Great North Road Solar & Biodiversity Park – EN010162
Carlton-on-Trent Parish Council – Reference number: [REDACTED]
Deadline 5 response

RE: RE: Water displaced by panels at Carlton-on-Trent

Site Access Locations
Figure A5.2.1NW
Great North Road Solar and Biodiversity Park
Environmental Statement

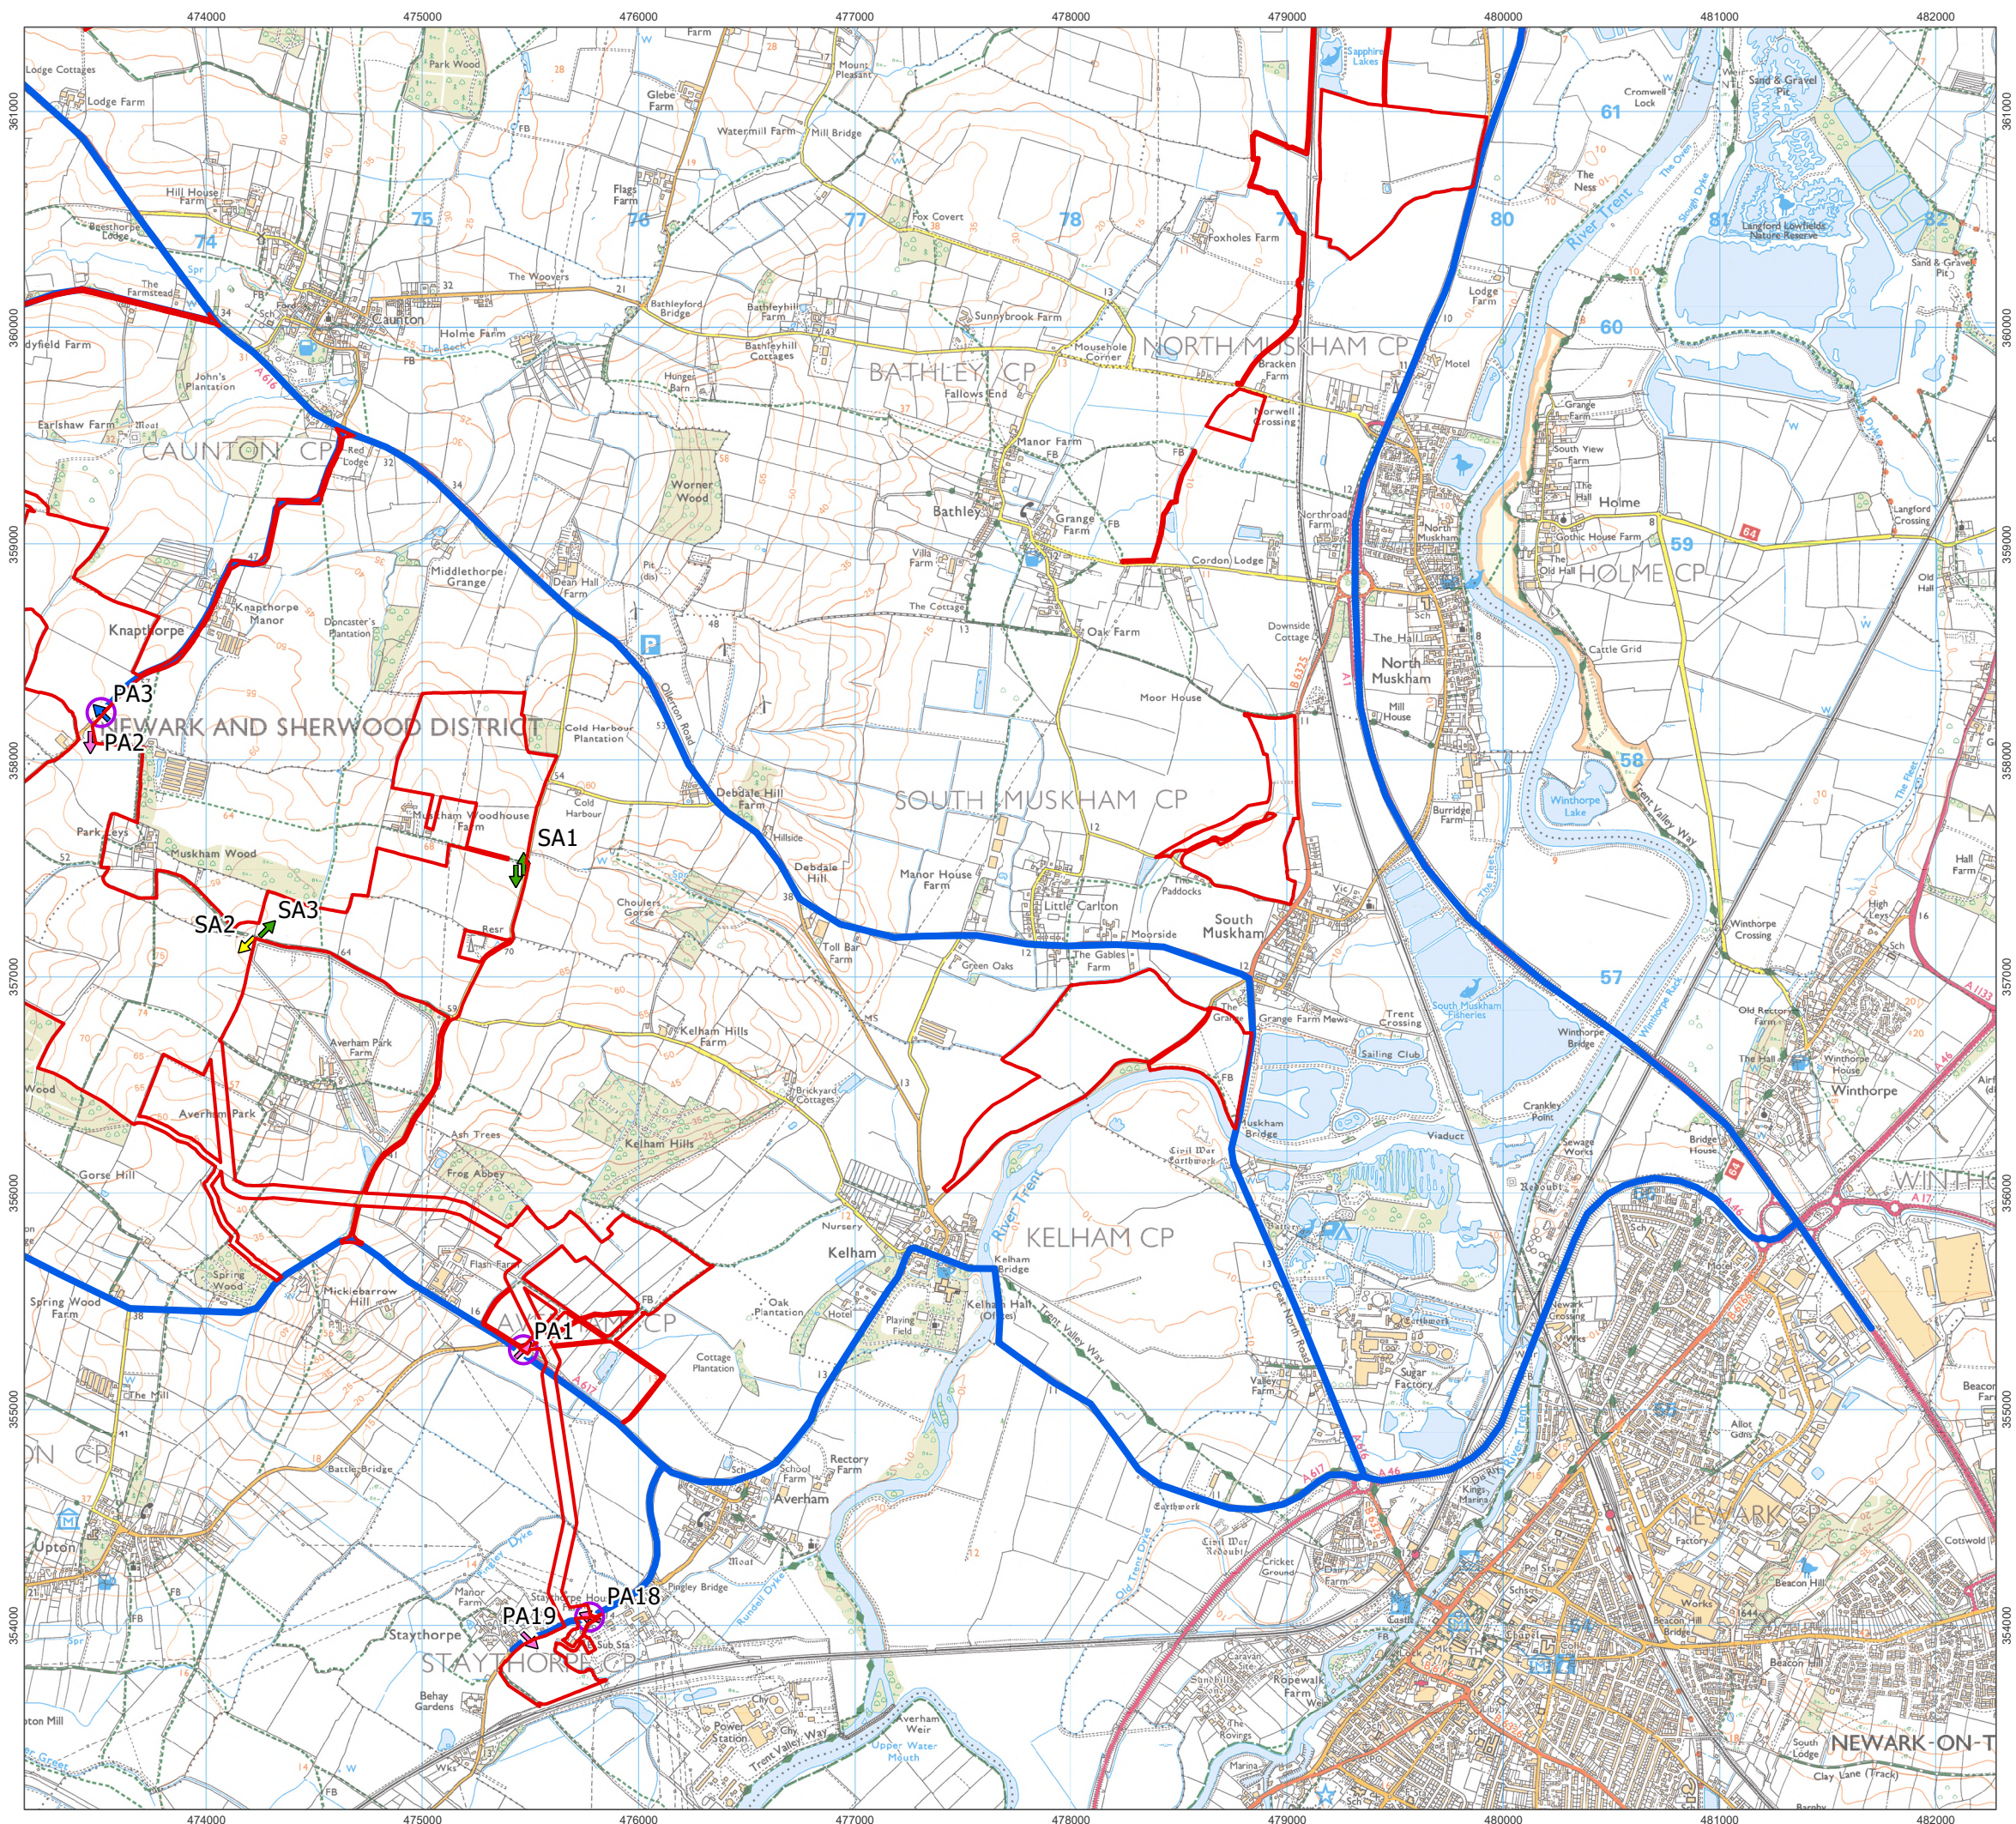
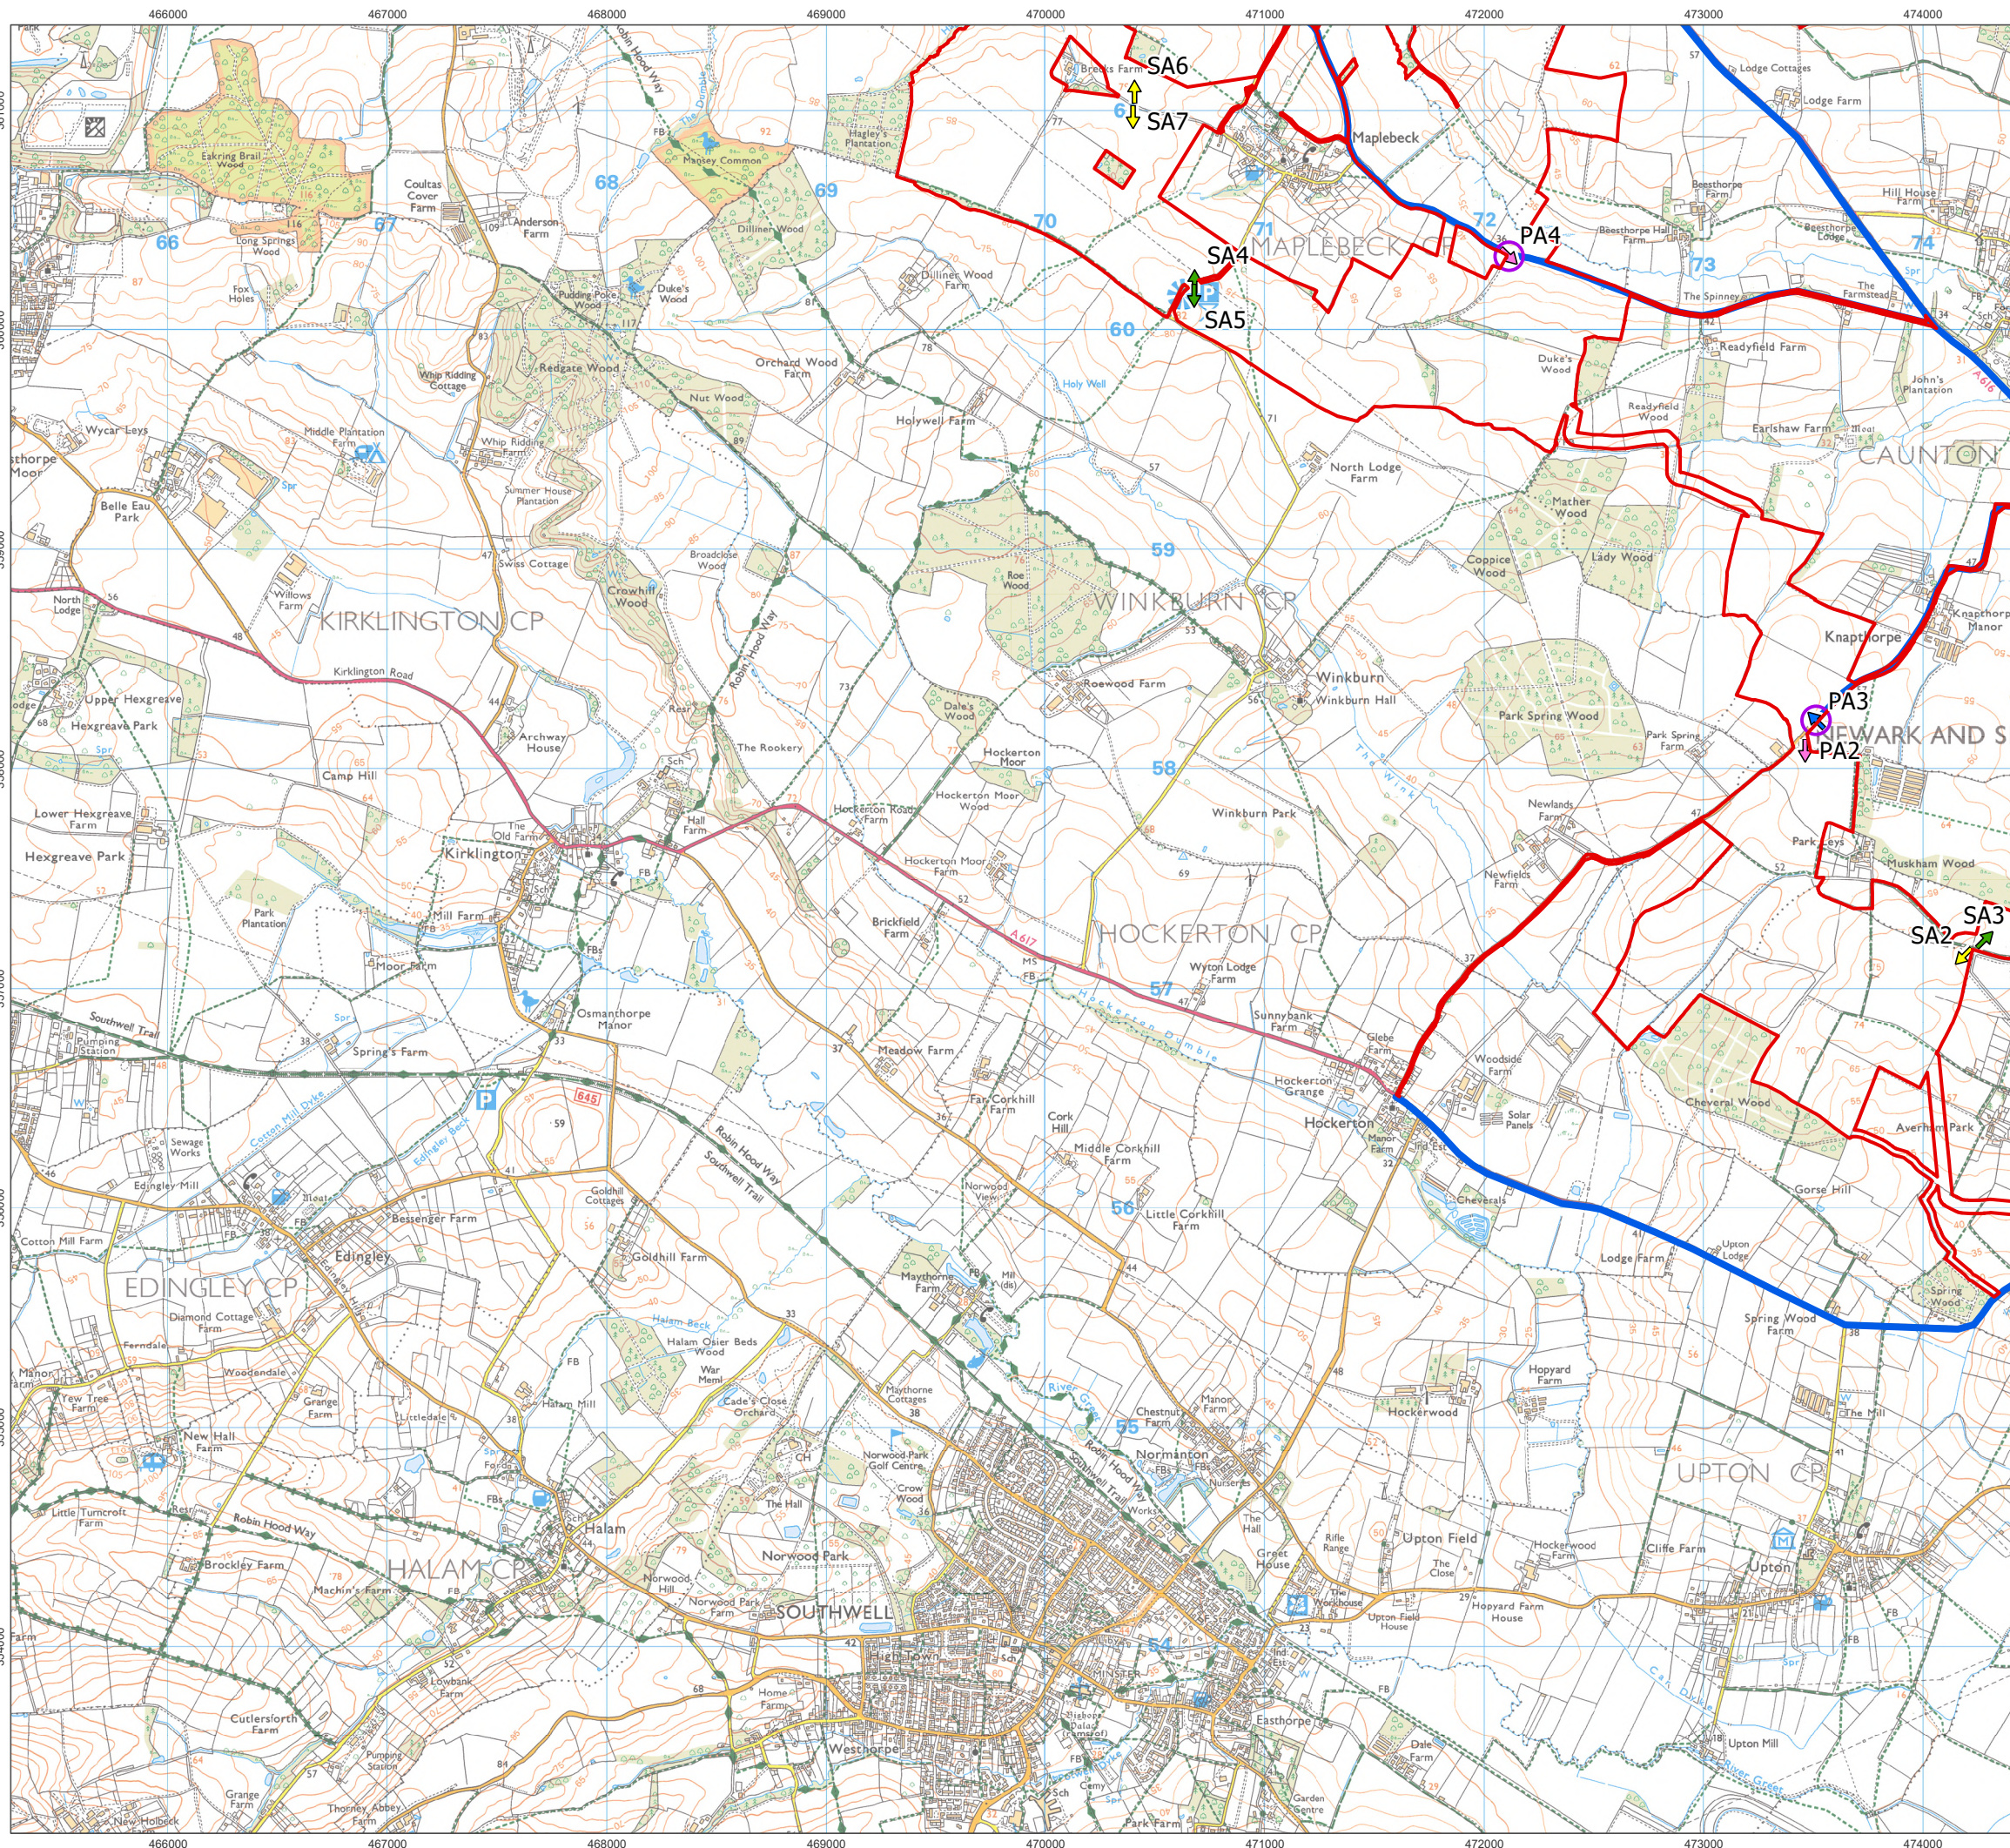
Again, we are focusing on the Carlton-on-Trent area and access to the proposed substation site, apologies I didn't make the clear previously. That said we were able to locate the site access point PA14, thank you.

- Site access arrangements are extensively detailed in ES Technical Appendix A5.2: [Construction Traffic Management Plan](#). An overview of the site access locations can be seen in Figure A5.2.1 presenting the location of the existing (to be upgraded) and new accesses proposed. Access drawings are included within Appendix D of the Transport Assessment [EN010162/APP/6.4.14.1]. These will all be subject to a Road Safety Audit process before construction.
